Parish council objection

Re CM/54/20/DOC

Drawing Title
Tree Retention & Protection Plan

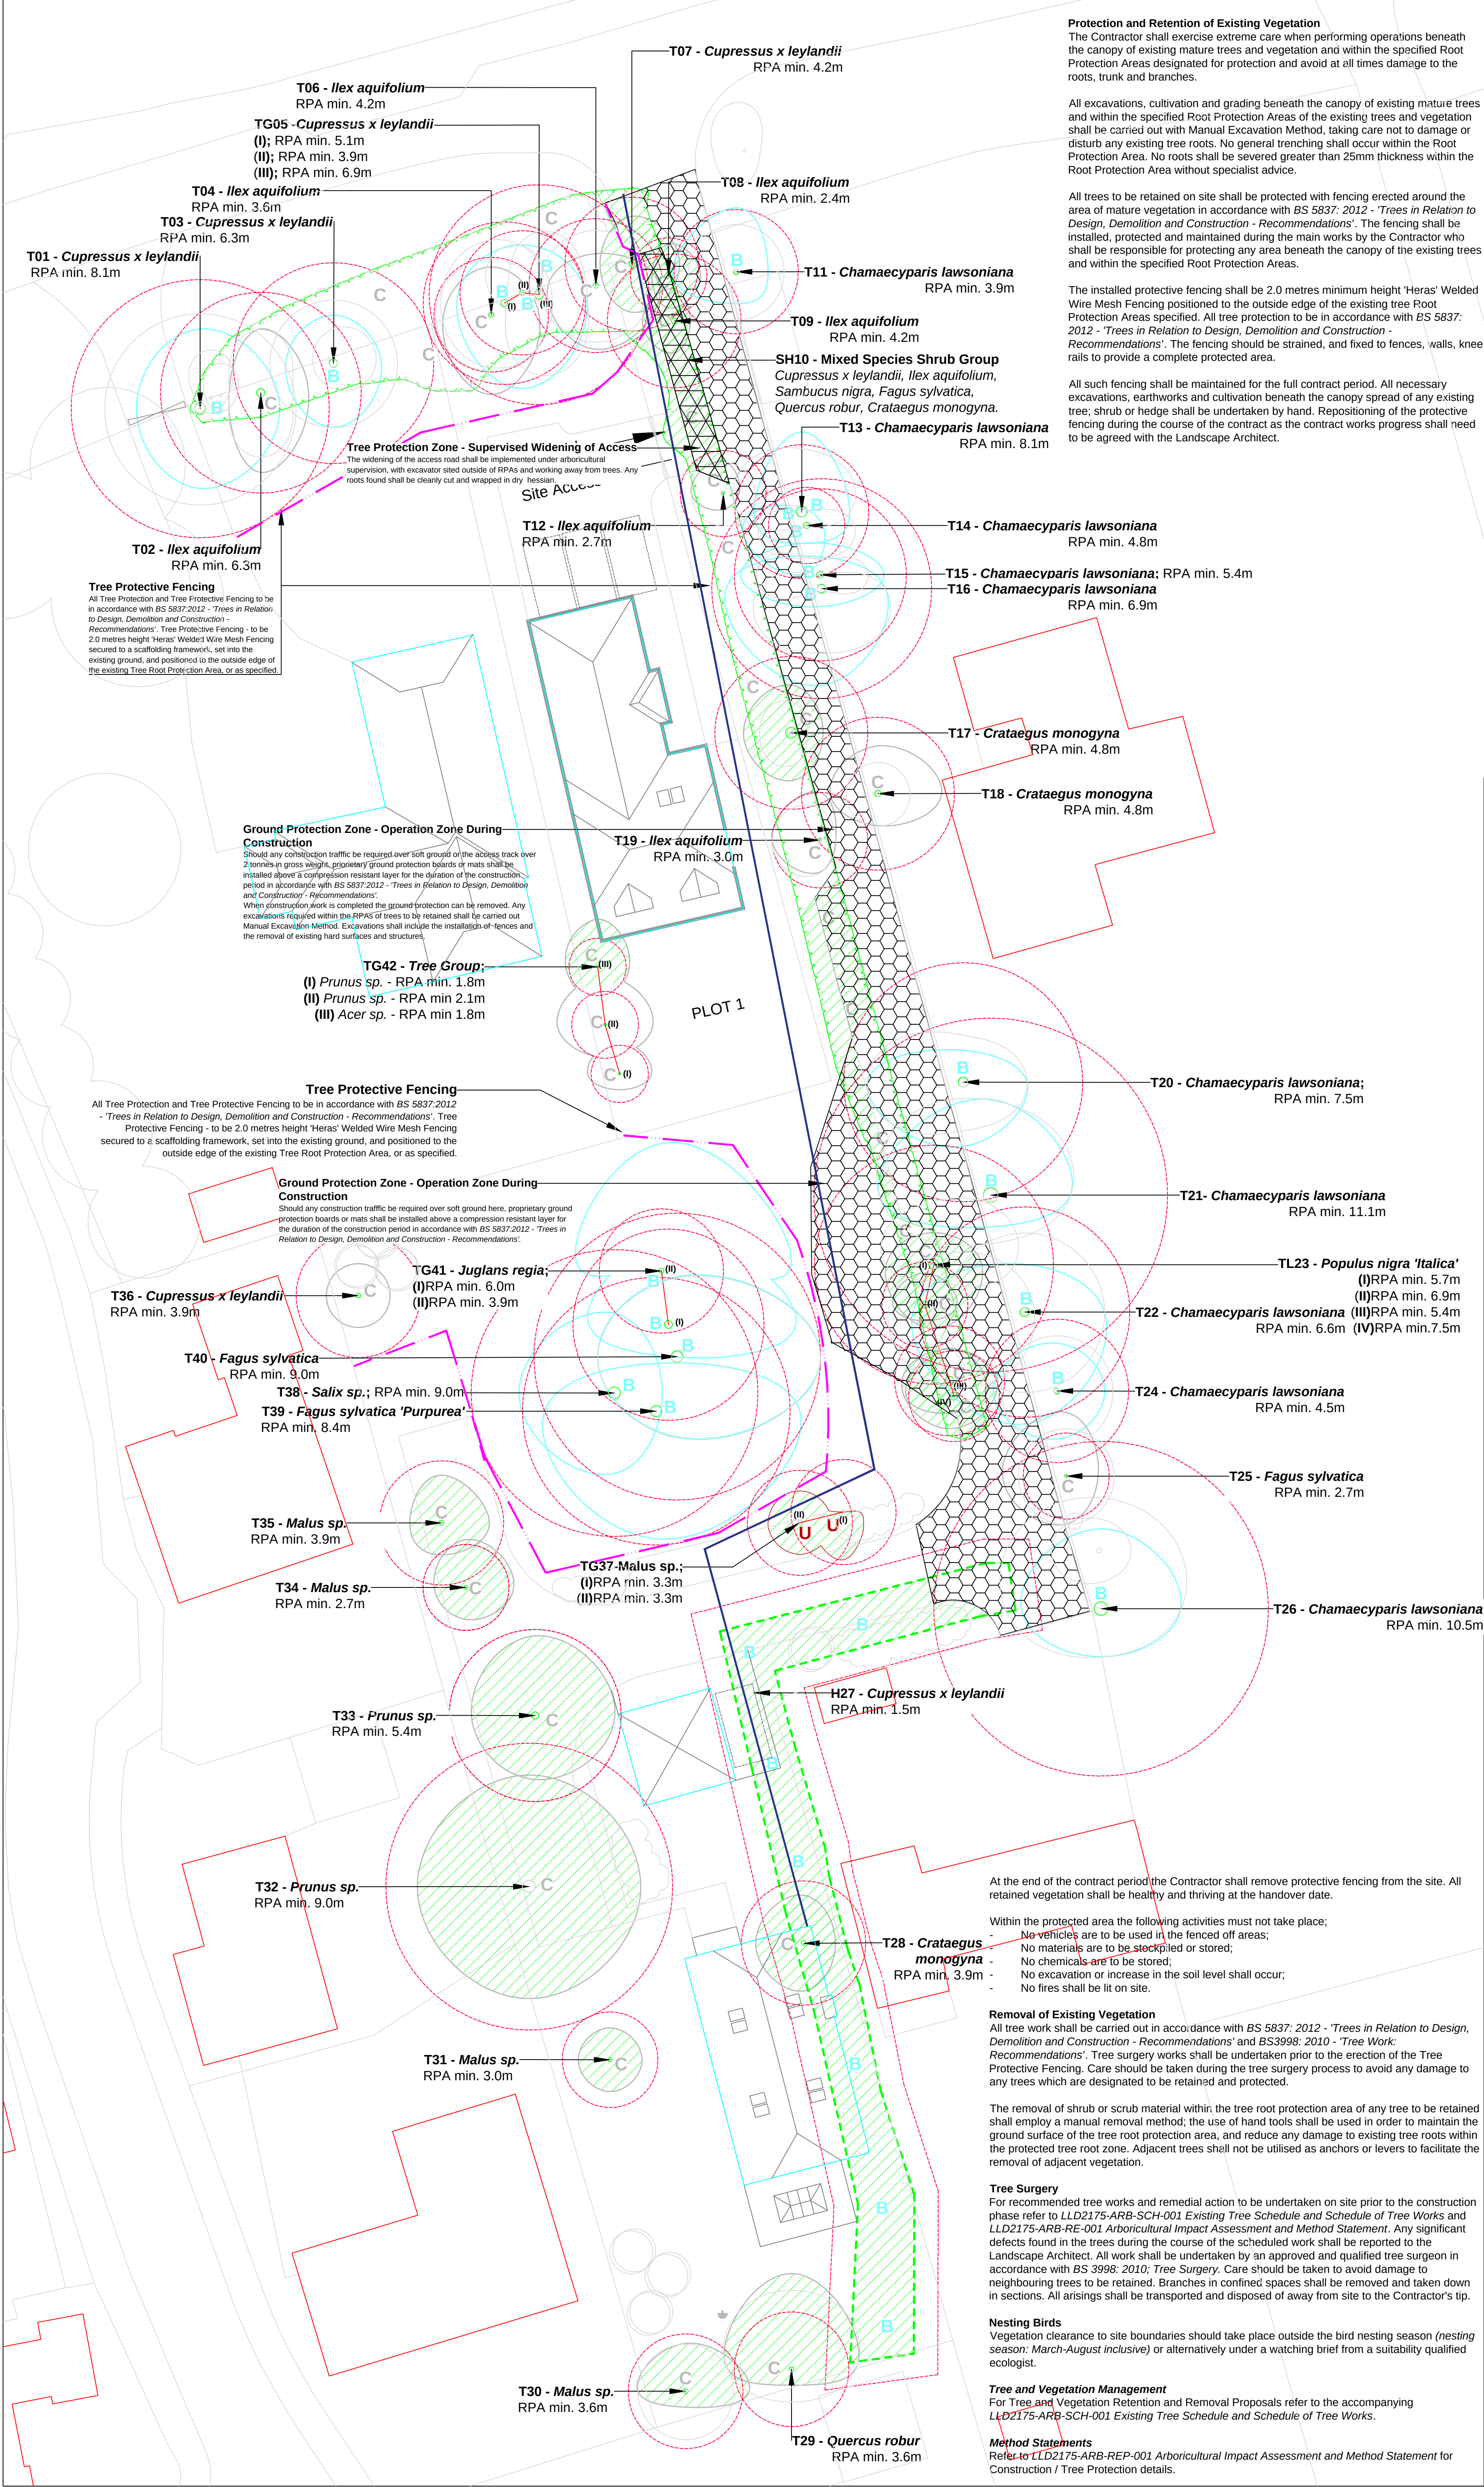
The Statement dated 11.12.2020 appears to contradict itself showing the beech Tree T40 to be subject to a Tree Preservation Order but also to be removed. The Tree Protection and Retention Plan Shows T40 to be retained.

If the proposal is for Tree T40 to be removed please treat this as an objection.
